STAGE 1 SHEPHERDS BAY RESIDENTIAL

S75W ACCESS REVIEW

Morris-Goding Accessibility Consulting

30th October 2013

UB-05
LG-05
GF-05
1-05
2-05
3-05
4-05

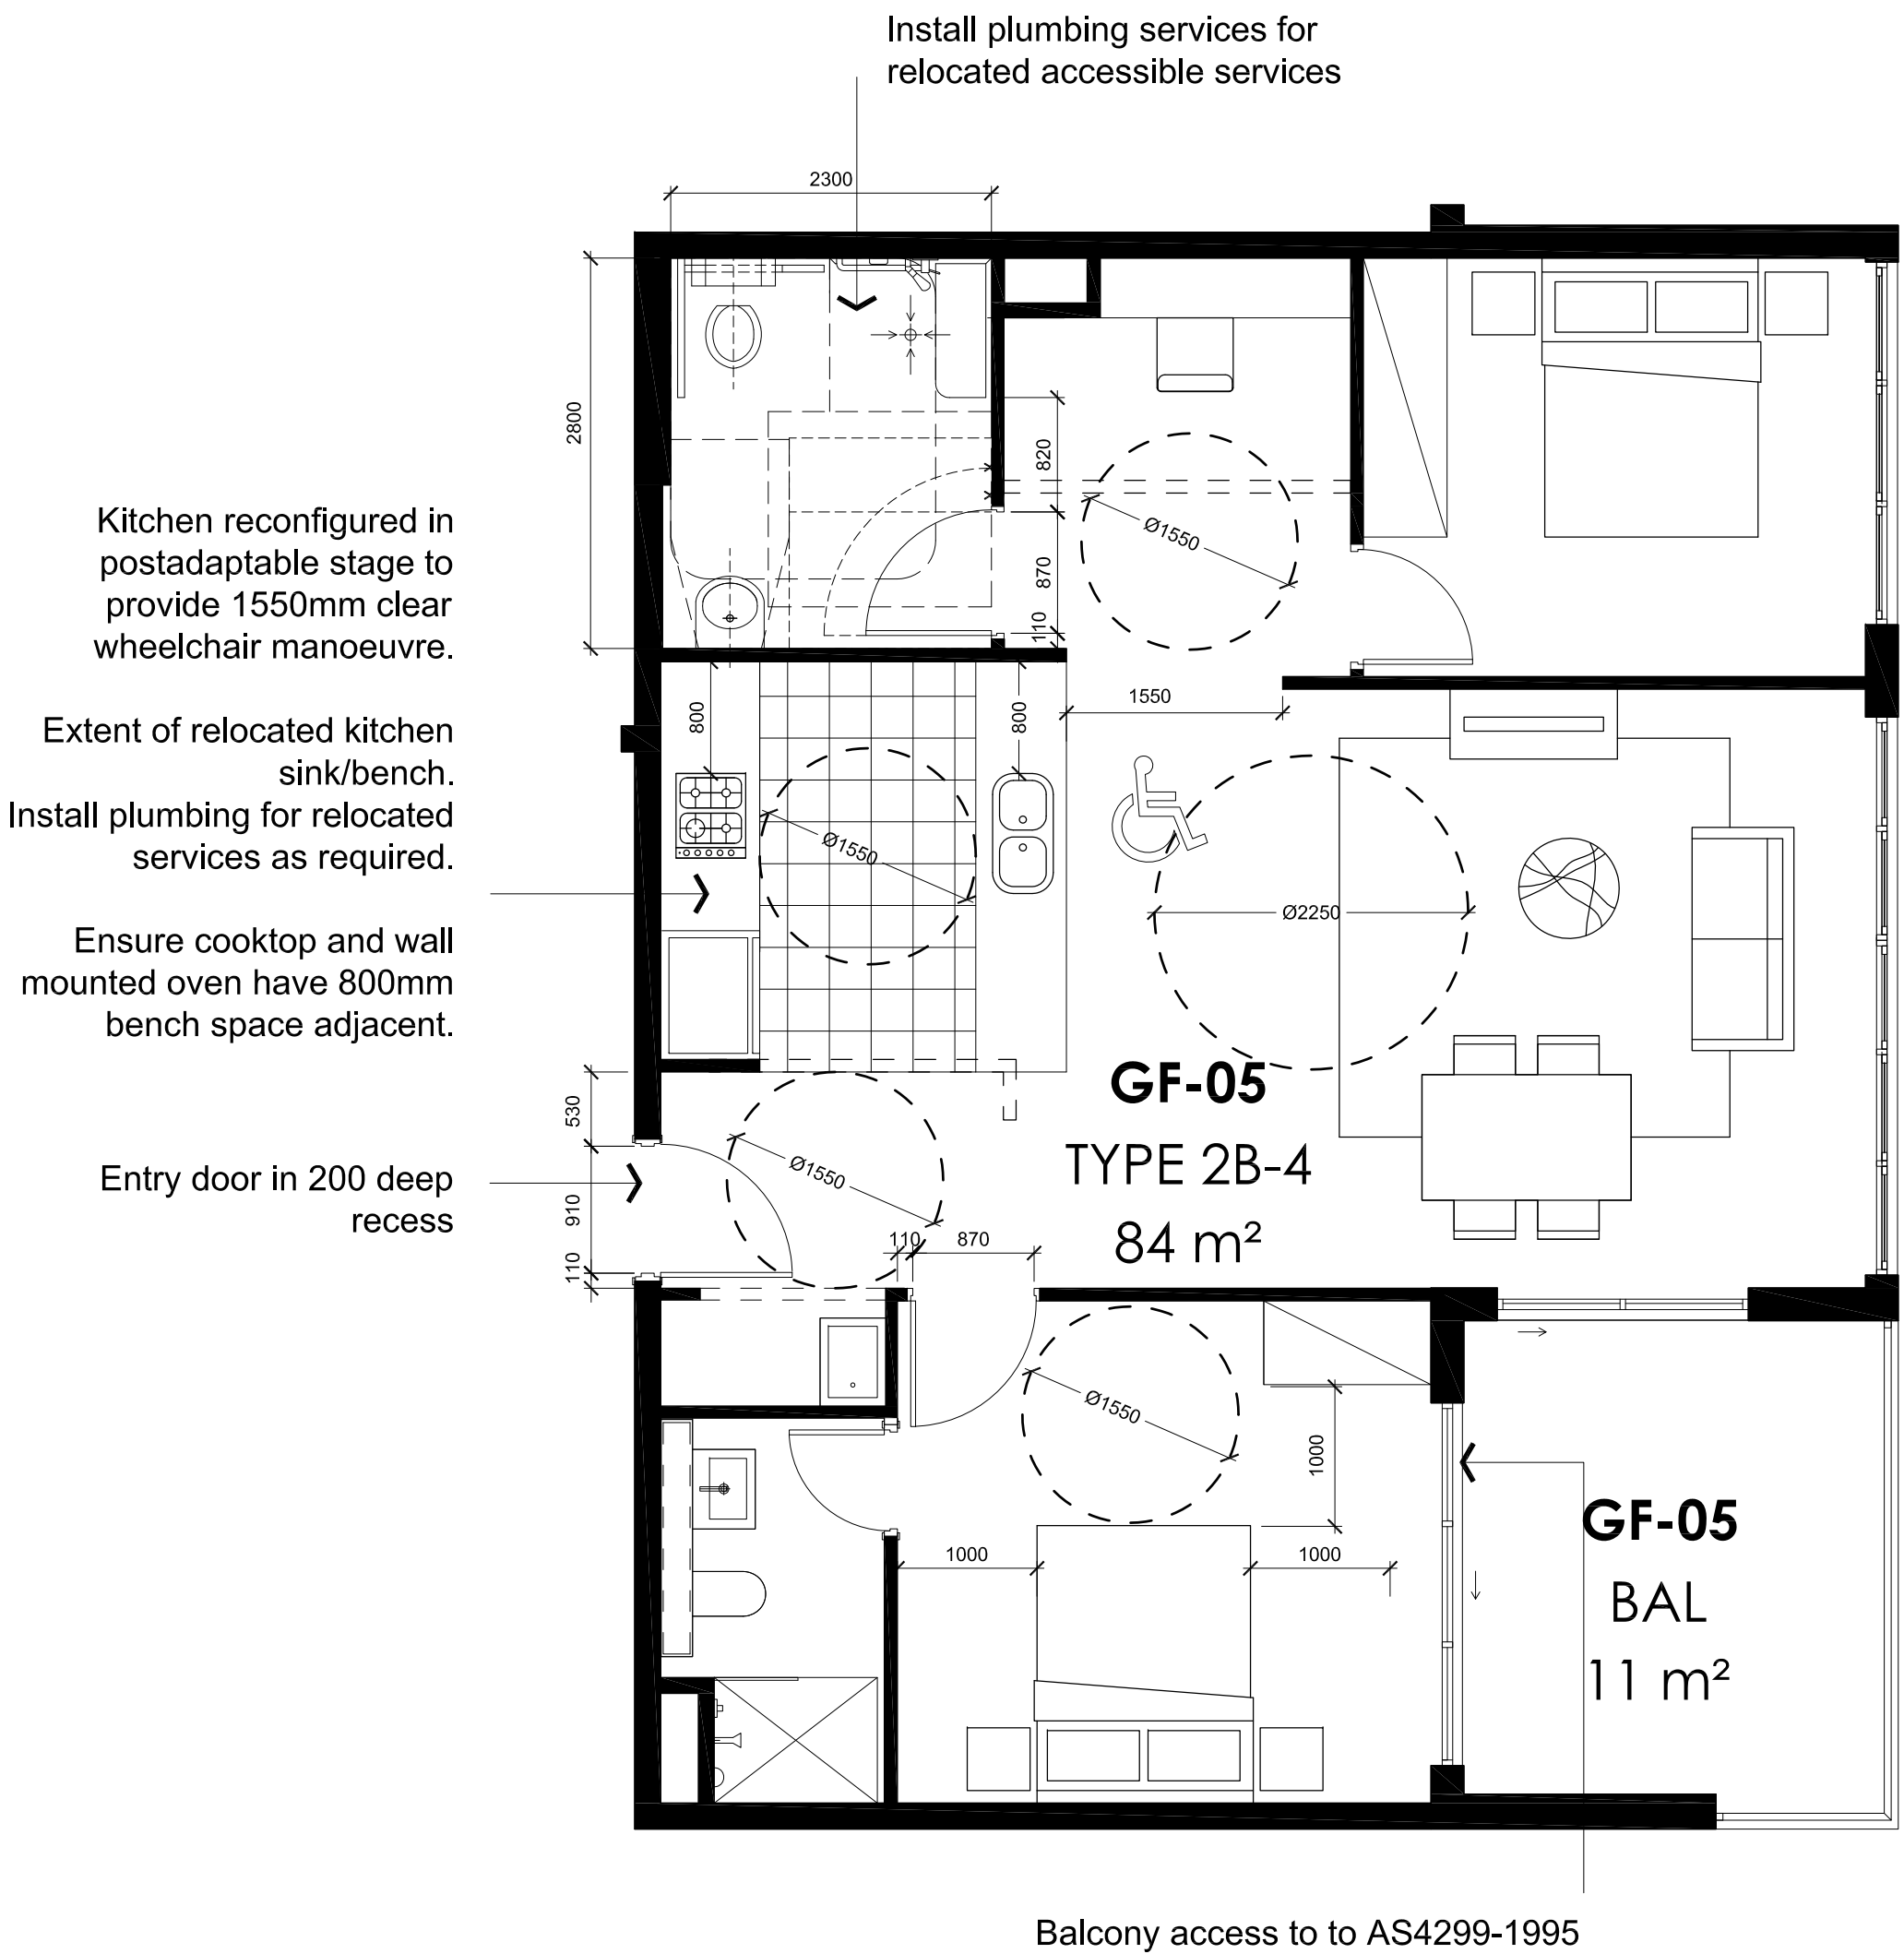
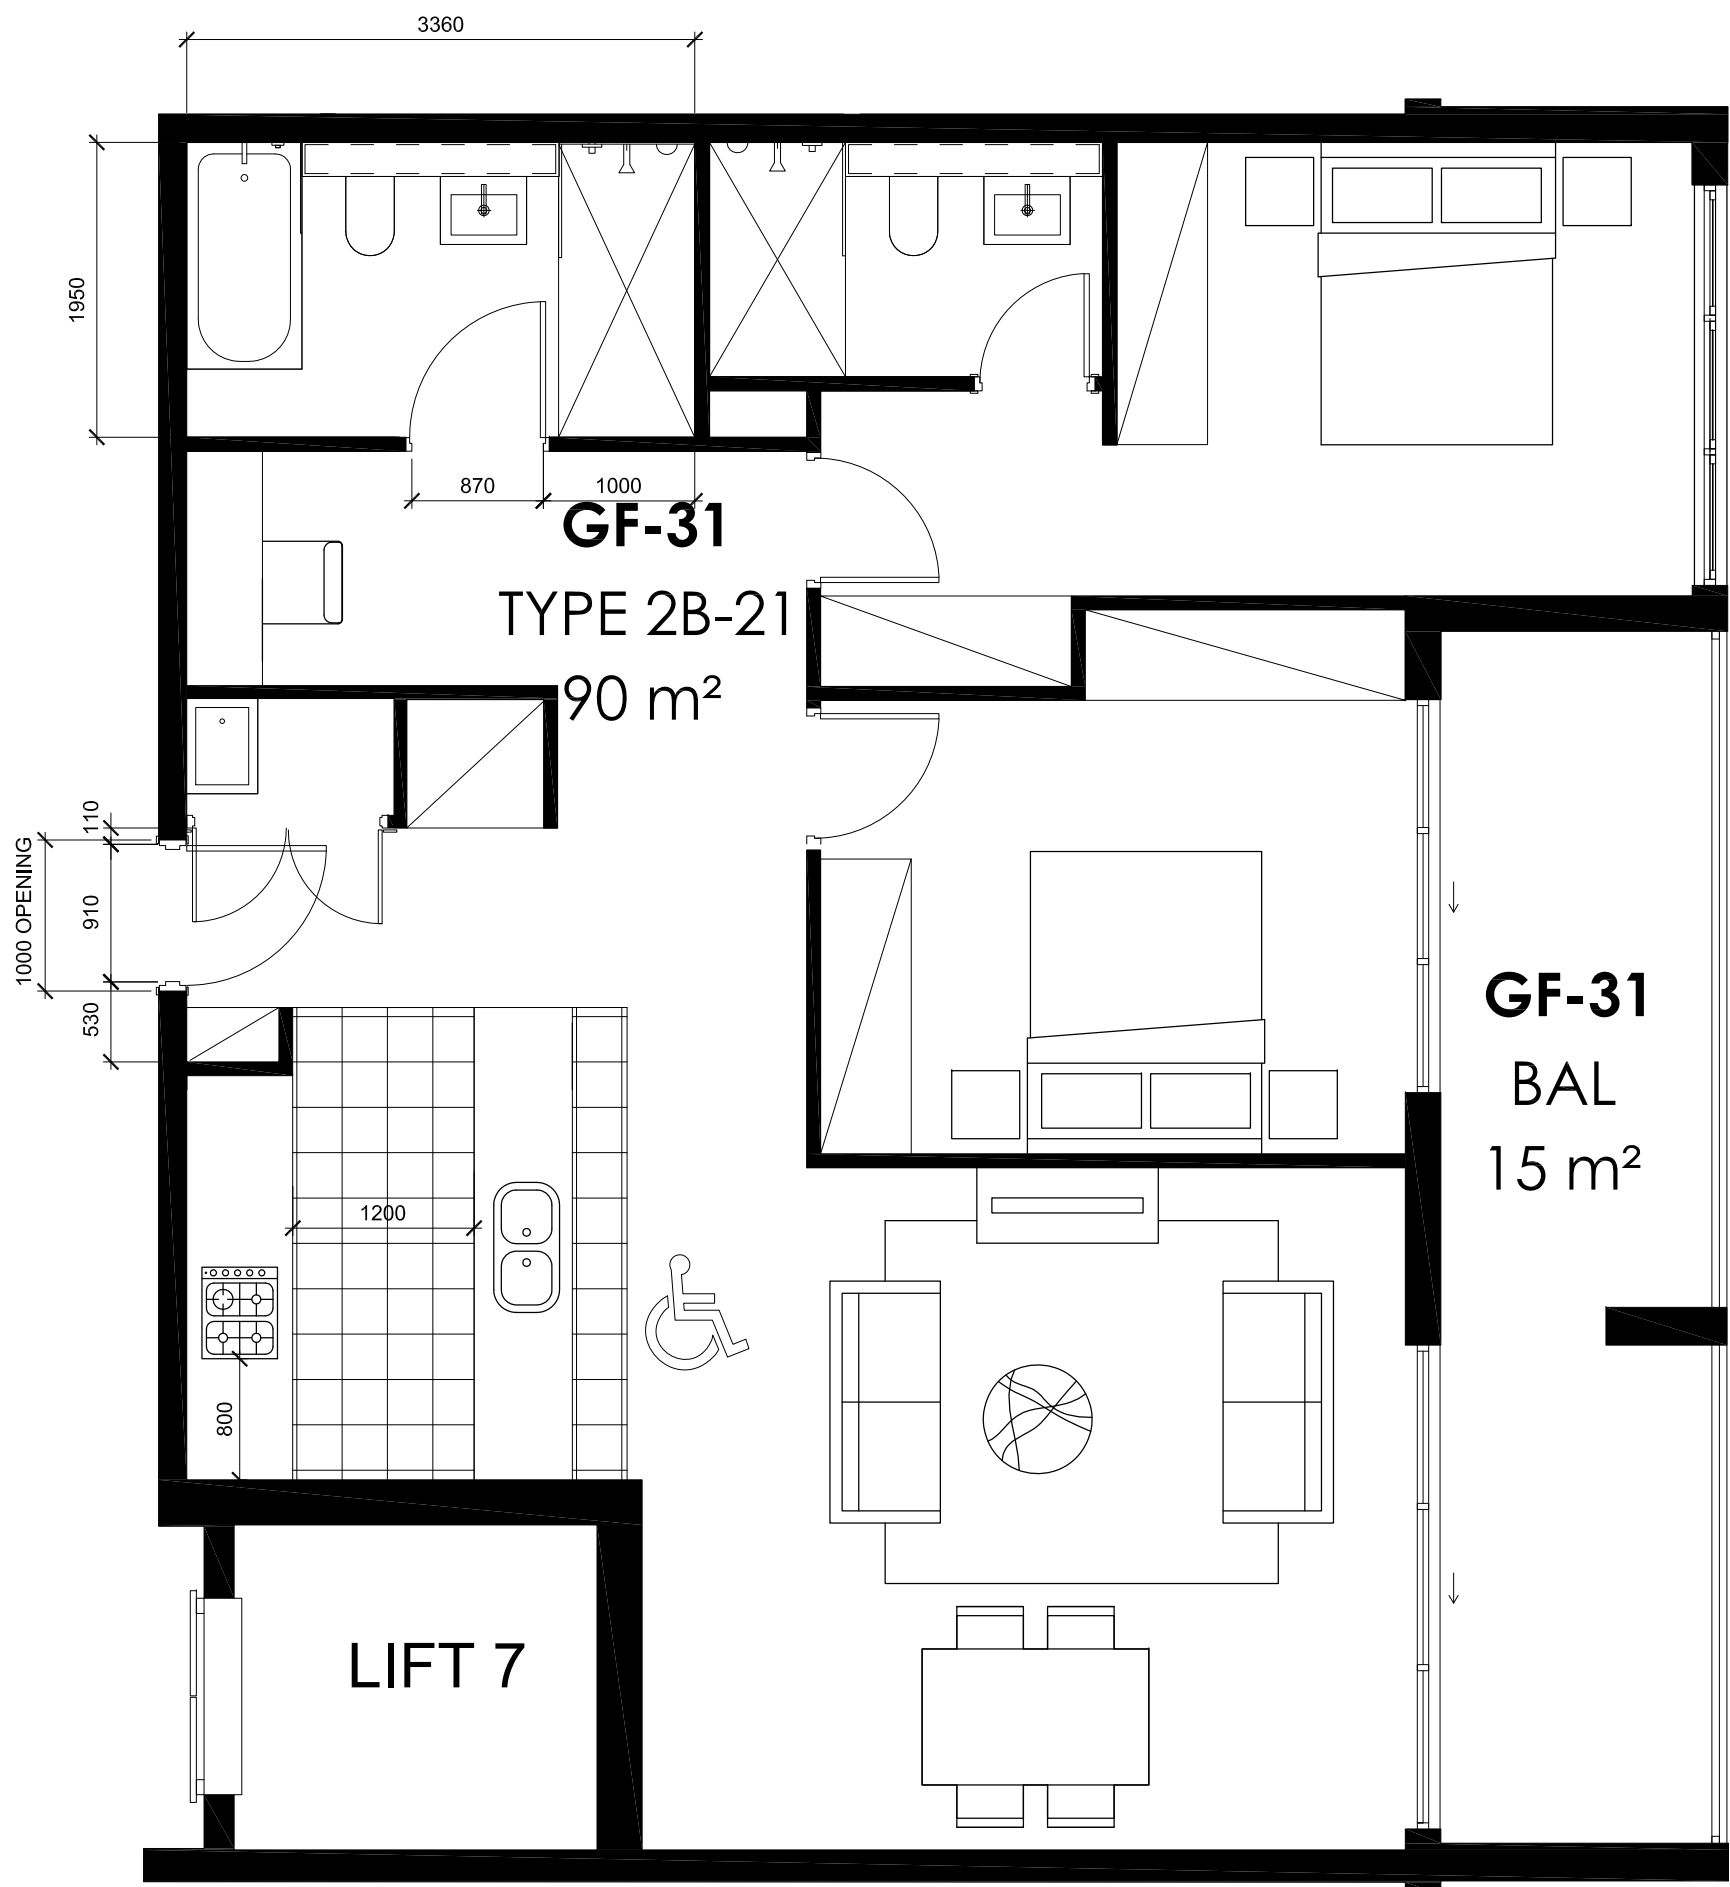
The adaptable unit entry door has appropriate clear width with appropriate 530mm latch side clearance once the storage area is removed compliant with AS1428.1 and AS4299.

There is a 1200mm clearance between kitchen benches at pre-adaptation stage. The kitchen bench is proposed to be relocated at post-adaptation to ensure a suitable 1550mm diameter turning area compliant with AS4299. Tiling has been provided to extend under the bench to allow post-adaptation modification of the island bench compliant with AS4299.
